**Response to SEARs – 17-23 Talavera Rd MACQUARIE PARK
DATA CENTRE – SSD-24299707**

RESPONSE TO SEARs REQUEST - CITY of RYDE
Project: SSD-24299707 – DATA CENTRE
Location: 17-23 Talavera Road, Macquarie Park
Applicant: Macquarie Data Centres

Project (SSD-24299707) – Council Reference COR2021/10

Trees to be retained inside site boundary: 29
 Trees to be removed inside site boundary: 55

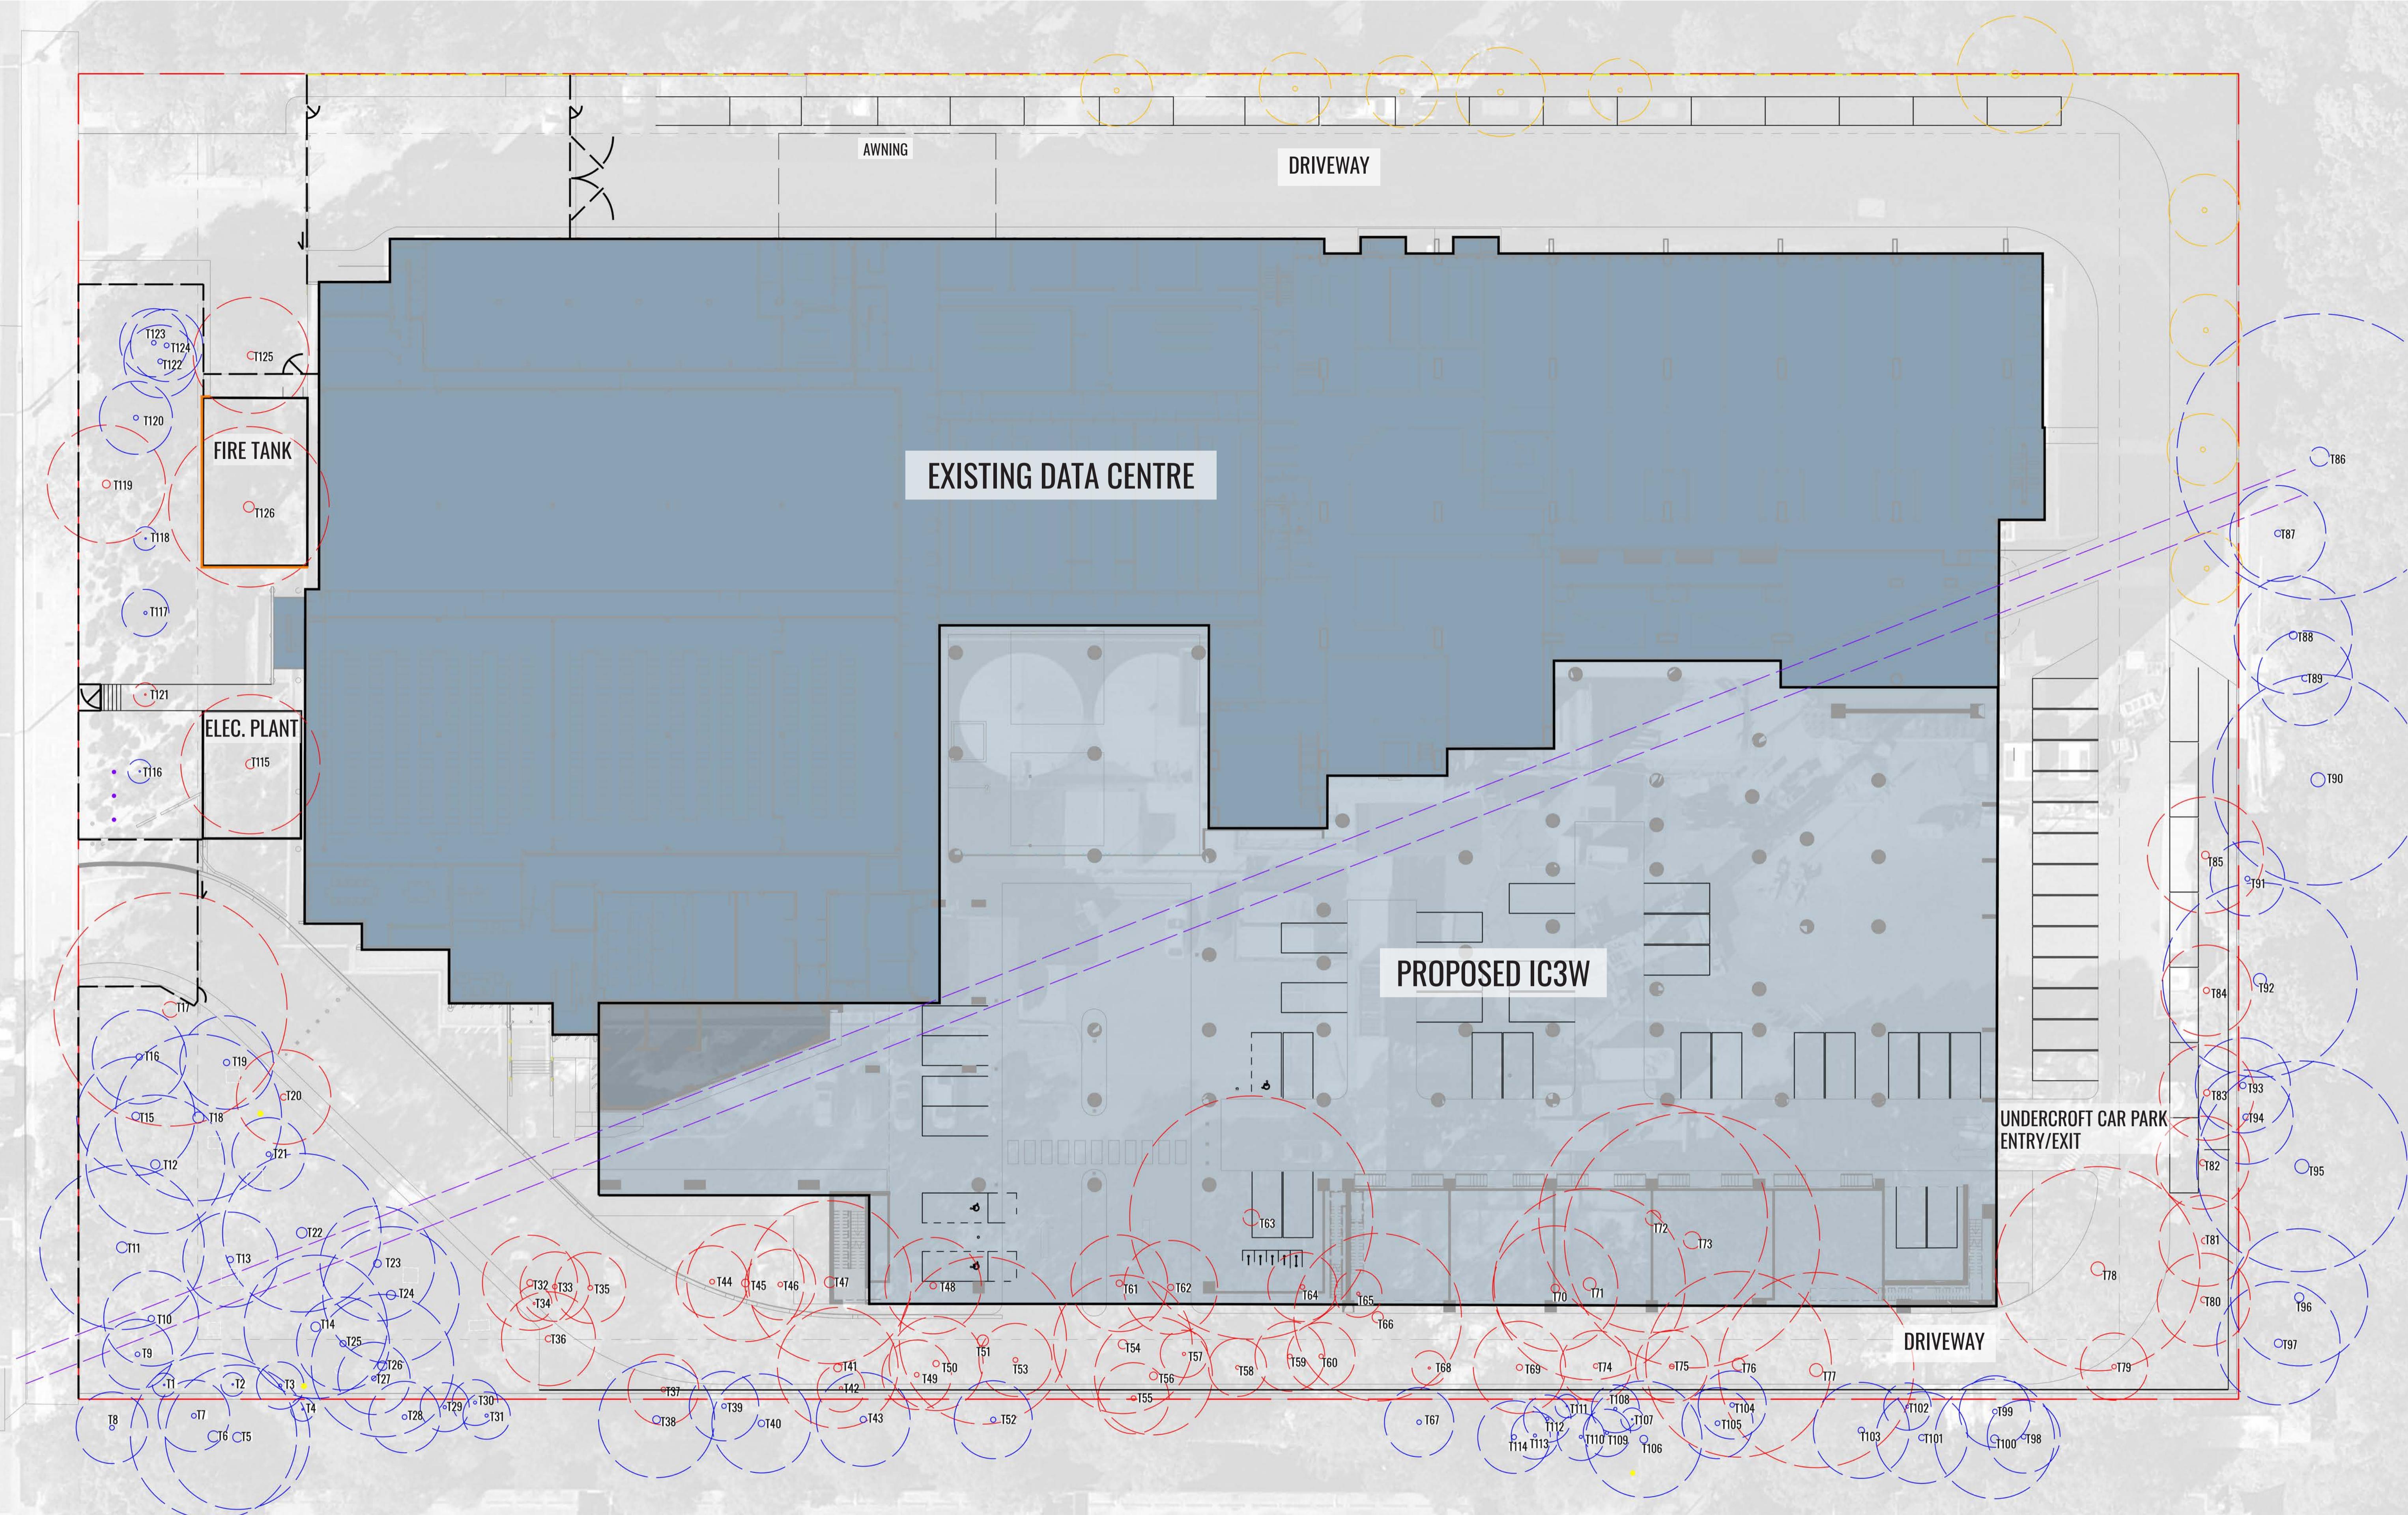
6.3. Impact to Existing Trees. Design changes should be undertaken to reduce the level of impact to existing protected trees to a sustainable level. This includes, but is not limited to; Trees 1, 1a, 2, 3, 4, 5, 6, 7, 8, 9, 10, 11, 12, 13, 15, 16, 17, 18, 19, 20, 21, 22, 23, 24, 25, 26, 56, 81, 84, 89 & 94 within the subject site and Trees 14, 83 & 95 within the neighbouring allotments – each of which were prescribed for retention under Condition 21 of the

SITEWORKS AND STORMWATER
MANAGEMENT PLAN**

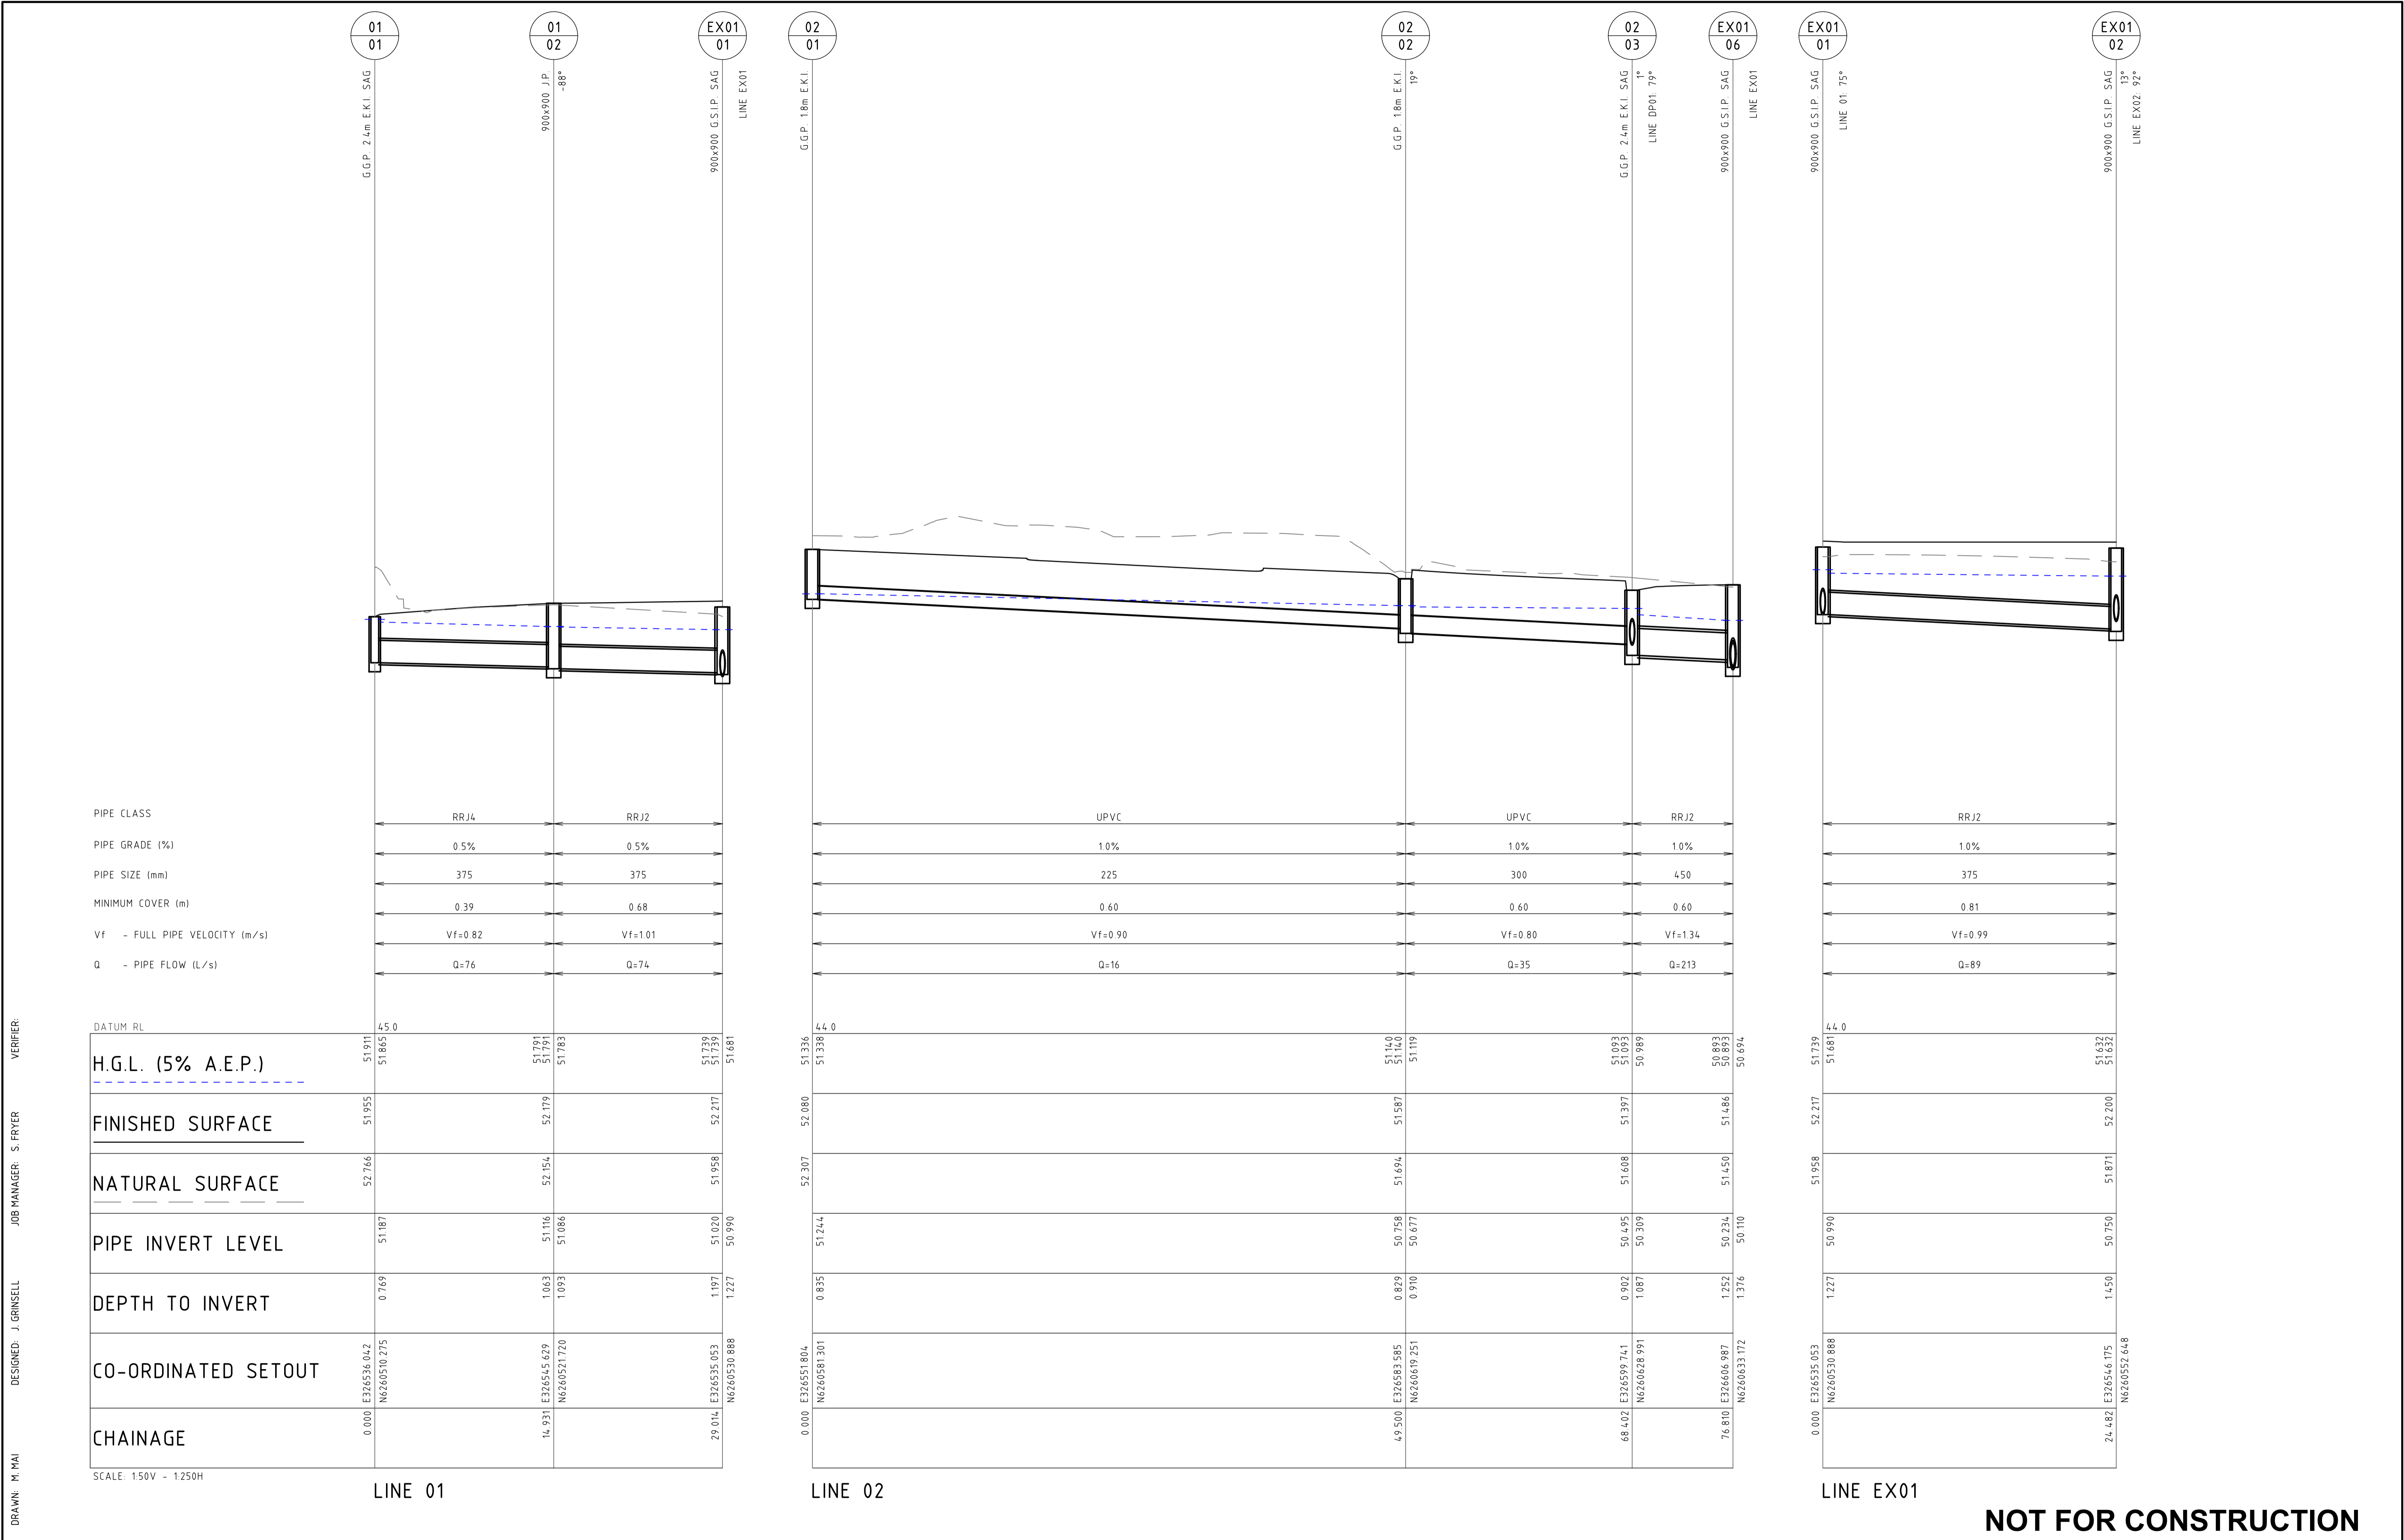
- 1.3. Despite the applicants insistence that the development will maintain clearance from the services, the concept plans depict a new column in the existing easement.

- 1.9. There is a 2.0m wide stormwater easement traversing the rear of the site which contains an active 675mm pipeline. This pipeline comes from the rear property. No new future building footprints should be encroached into this easement or the proposed drainage easement.
